**From:** [Alexandra Power](#)  
**To:** [Duncan Upton](#)  
**Cc:** [Development West](#); "[Natasha Homsey](#)"; "[nestor.tsambos@planning.nsw.gov.au](mailto:nestor.tsambos@planning.nsw.gov.au)"; "[Kayla Robson](#)"  
**Subject:** RE: Wollar traffic modification  
**Date:** Monday, 11 April 2022 4:07:40 PM  
**Attachments:** [image001.jpg](#)  
[image002.jpg](#)

On review of the proposed modification TfNSW provides the following comments:

Appendix E Proposed haulage site access routes

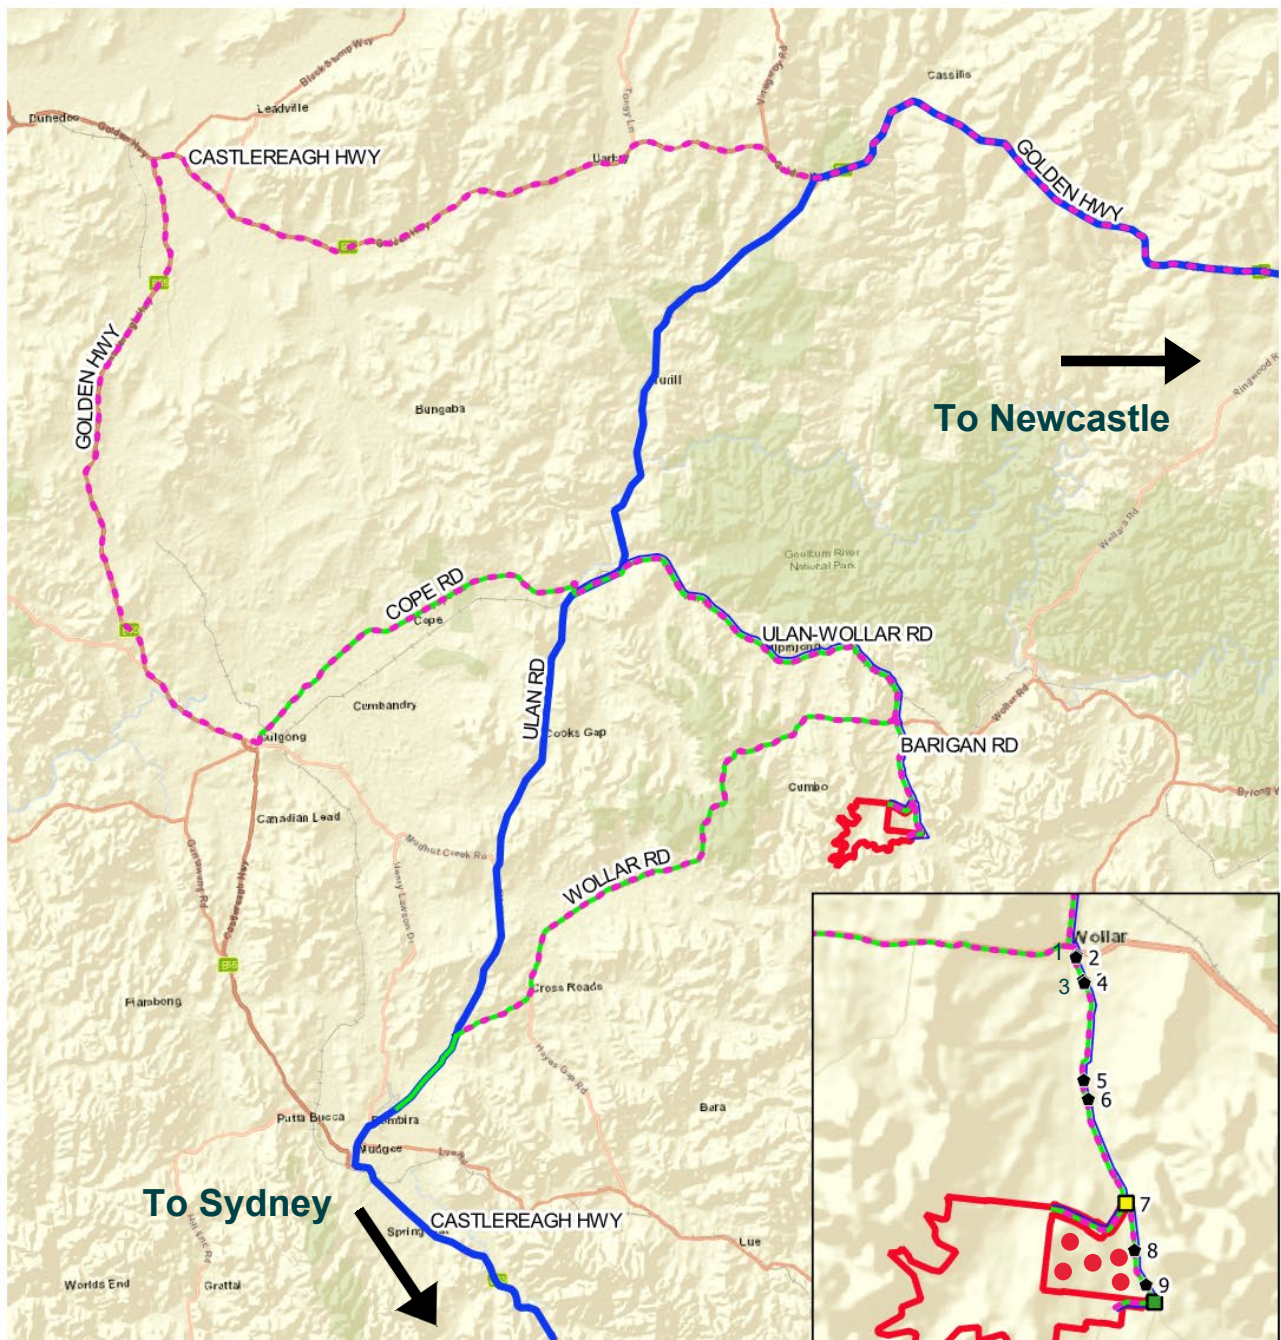
- Point 3- OSOM Movements- A route assessment would need to be prepared for the proposed change to the OSOM route to identify any road works required along the state and local classified road network, to enable the assessment of the environmental impacts by the consent authority as a part of the modification to the approved development. It is noted that a number of the roads identified within the OSOM alternative route will be local roads and there will need to be discussions as to how this will be managed with Mid-Western Regional Council. What will be the alternative route if this route is not permitted by Mid-Western Regional Council. There will also need to be considerations around night travel and other issues
